**ENVIRONMENTAL ASSESSMENT OF WOLLONGONG COAL RUSSELL VALE
COLLIERY
PRELIMINARY WORKS PROJECT MODIFICATION 2 NO. MP 10_0046**

SYDNEY CATCHMENT AUTHORITY - SUBMISSION

PRELIMINARY WORKS PROJECT

WOLLONGONG COAL RUSSELL VALE COLLIERY

Figure 14 details the known structures in the Bulli Seam for the Wonga East Study Area. These structures have been derived from detailed examination of available mine plans. Each structure is annotated for easy reference and discussed in the following sections on faulting and igneous intrusions.

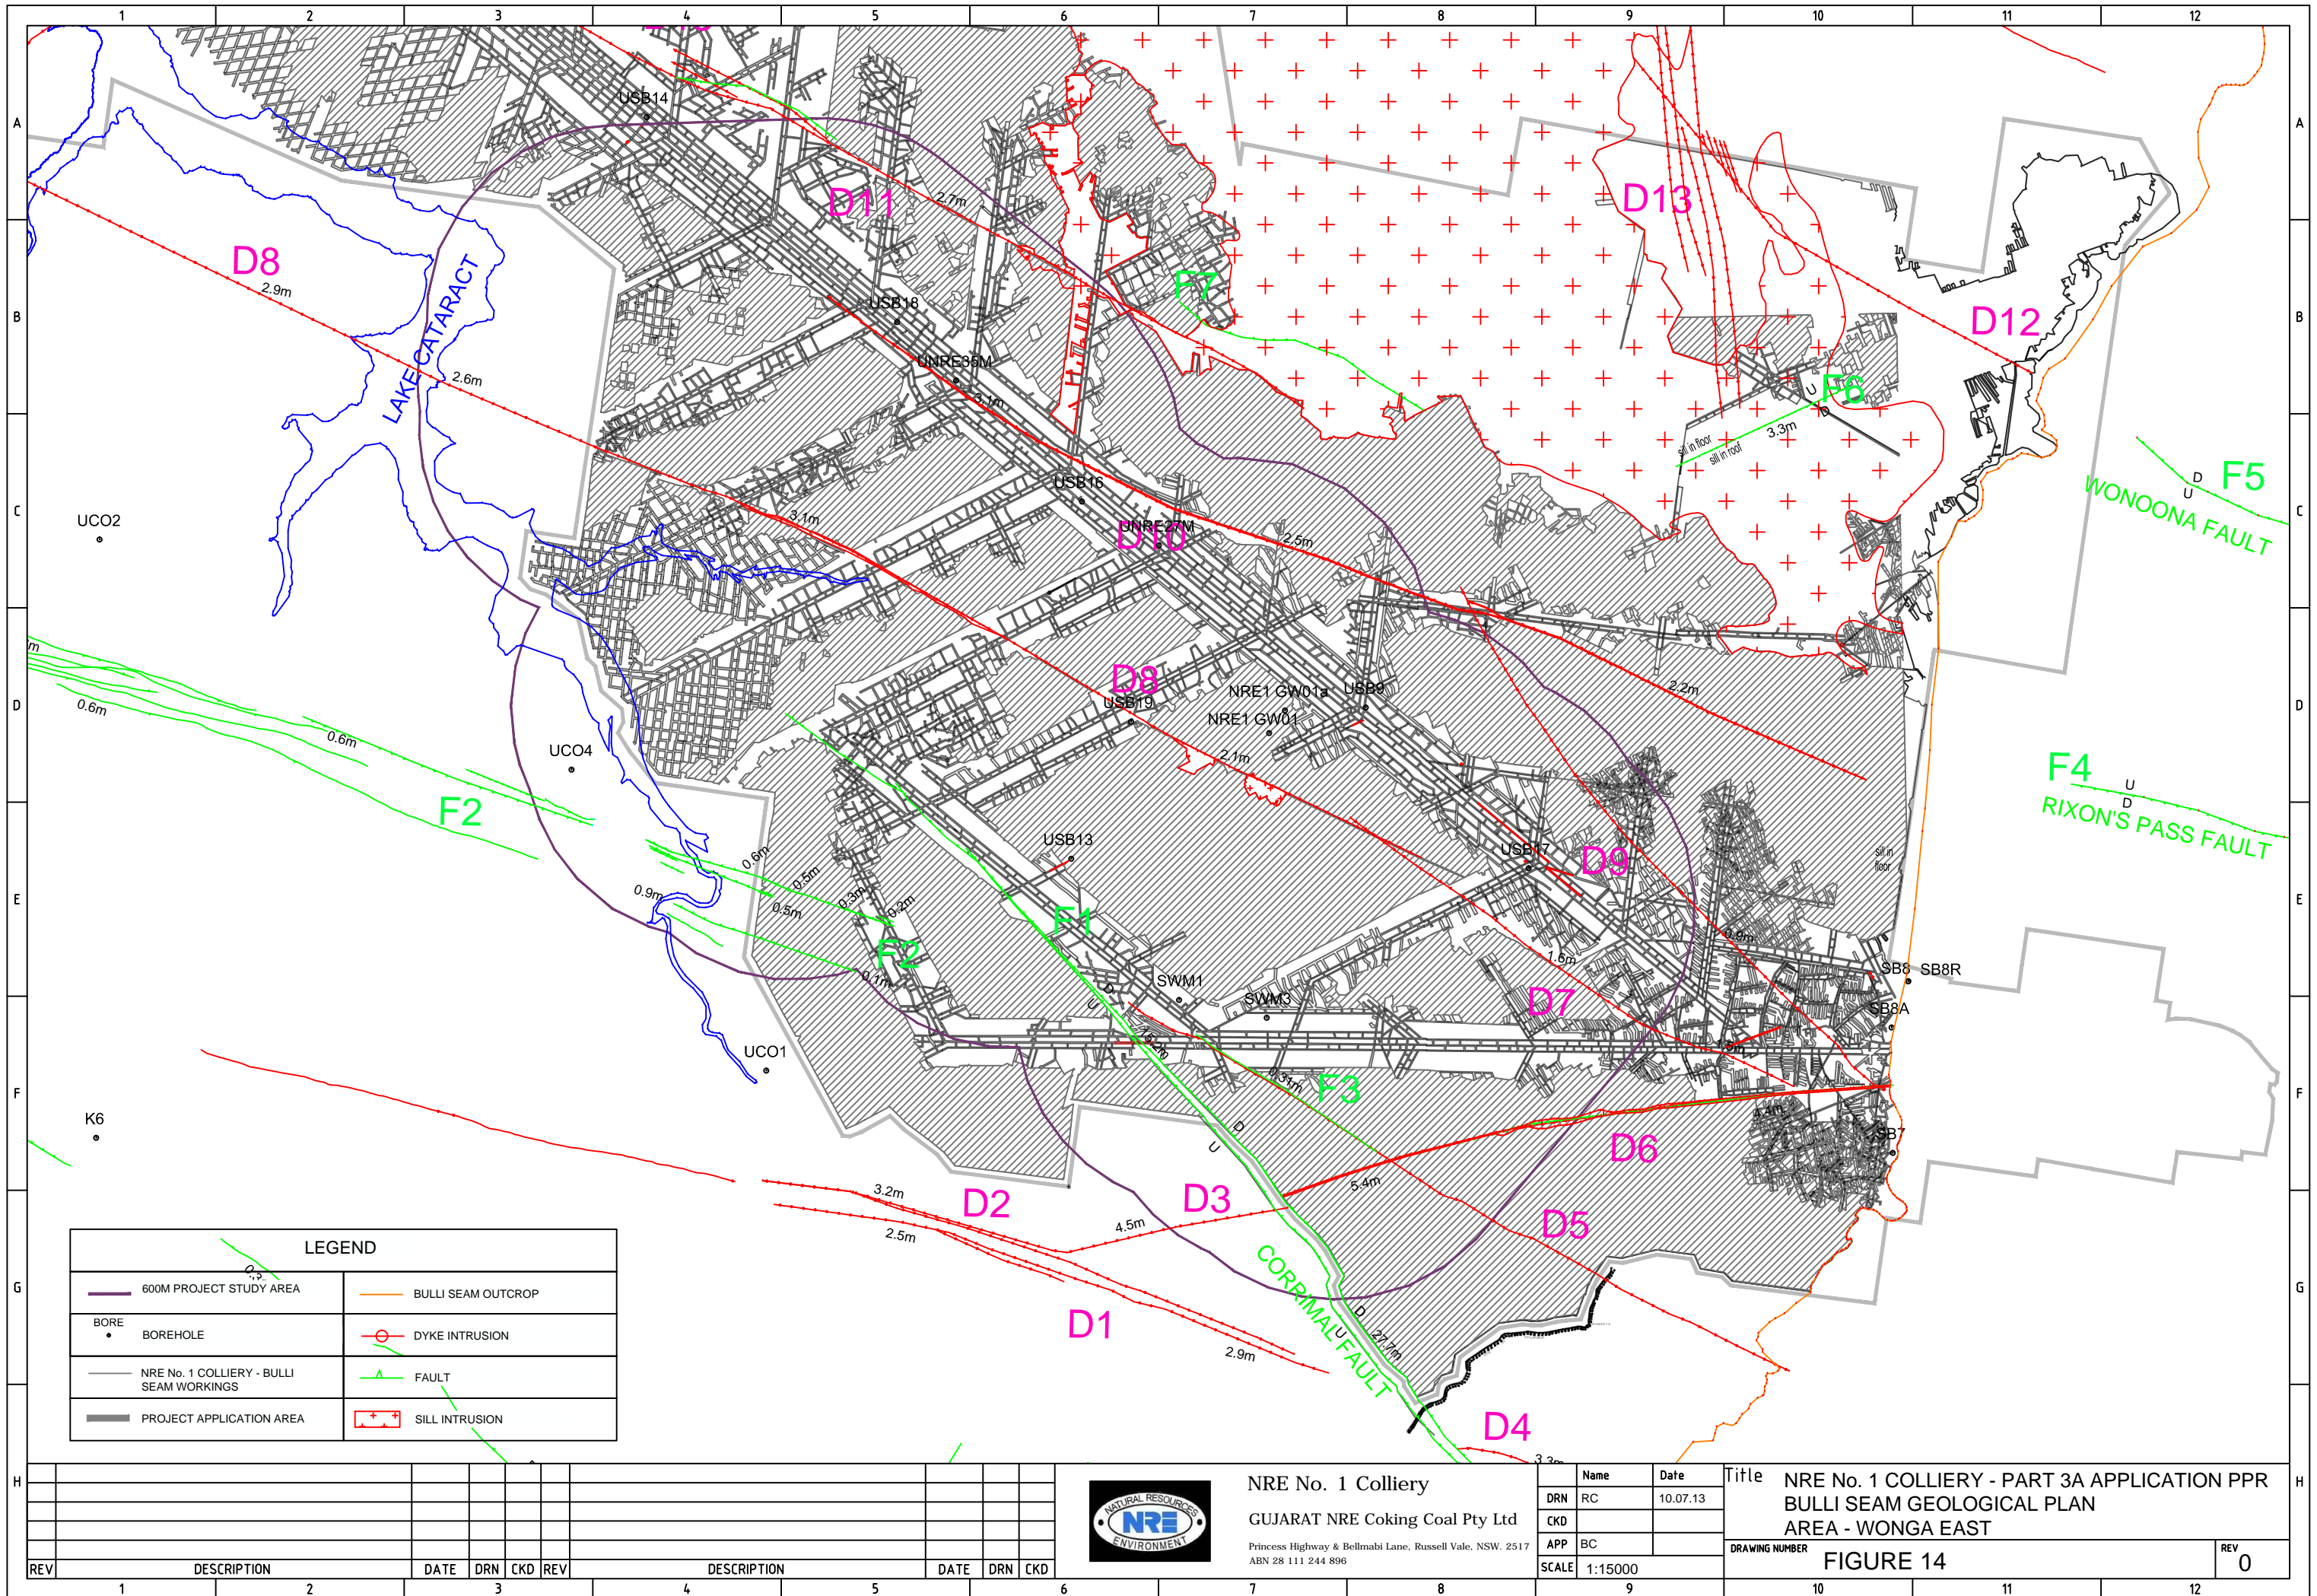
The SCA has previously raised concerns about the knowledge of the extent of faulting and the presence of dykes within the vicinity of Longwall 6. This concern remains and is shared by the Dams Safety Committee. The particular concerns are that:

- The Corrimal Fault has been intersected by the Longwall 6 gateroads and the fault does not appear to be petering out (as claimed by Wollongong Coal).
- A dyke (D8) is present in the Longwall 6 gateroad workings and is exposed in the sides of the reservoir.

The SCA is aware that the zone where the Corrimal Fault is associated with small sub parallel faults this has caused significant roof deterioration of the Longwall 6 gate road. The implications of this needs to be better understood.

It is critical that the understanding of the extent of the Corrimal Fault and the implications of dyke D8 is fully understood prior to a decision to approve mining.

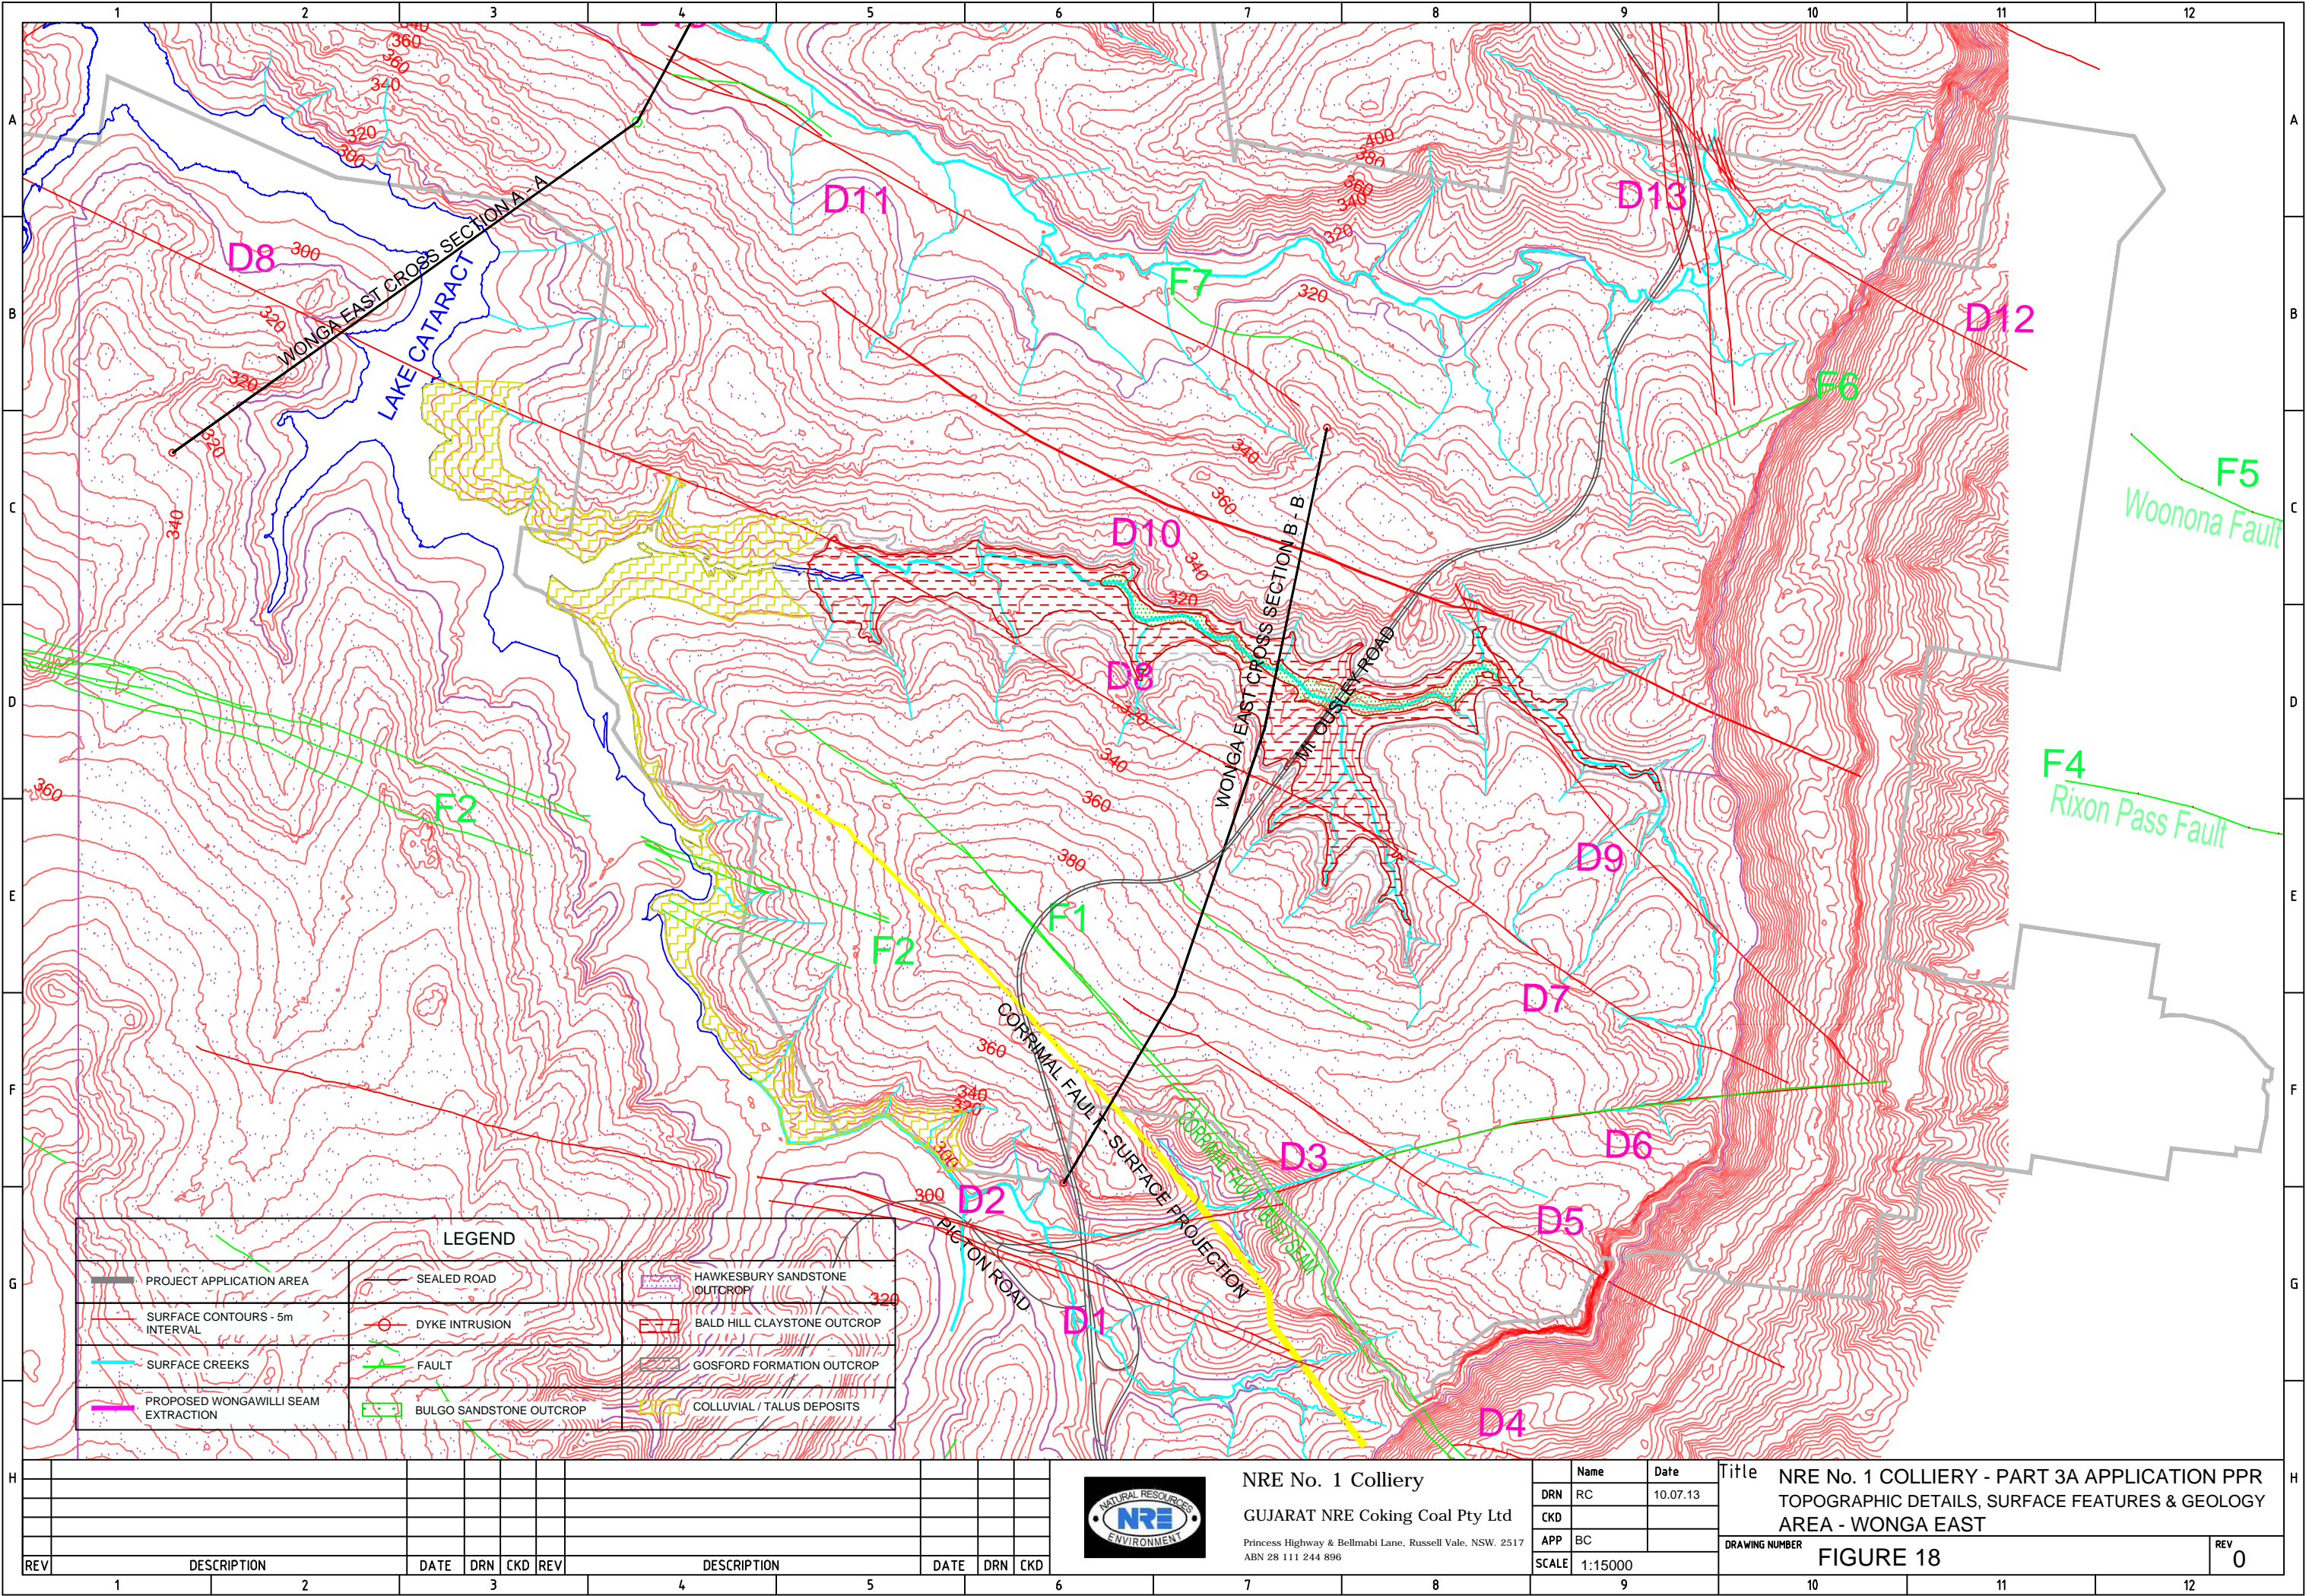
There is a likely chance that the Corrimal Fault will also intersect the confluence of Cataract River and Cataract Creek. In addition, the close proximity of the western end of Longwall 6 (the starting position of the 400m initial extraction proposal) to the full supply level of Cataract Reservoir and the shallow depth of cover do not provide SCA with a high level of confidence that there will be no hydrologic connection between the workings and the stored water.

A risk assessment on the potential for hydrologic connection between mine workings and stored waters as well as surface/groundwater and mine workings should be carried out with the top event assuming a fault zone associated with the Corrimal Fault given the occurrence of parallel to sub-parallel faults and dykes in the downthrown side of the Corrimal Fault. The apparent lack of surface expression of these geological structures does not mean they do not exist. It could mean these features are concealed by more recent alluvial deposits.
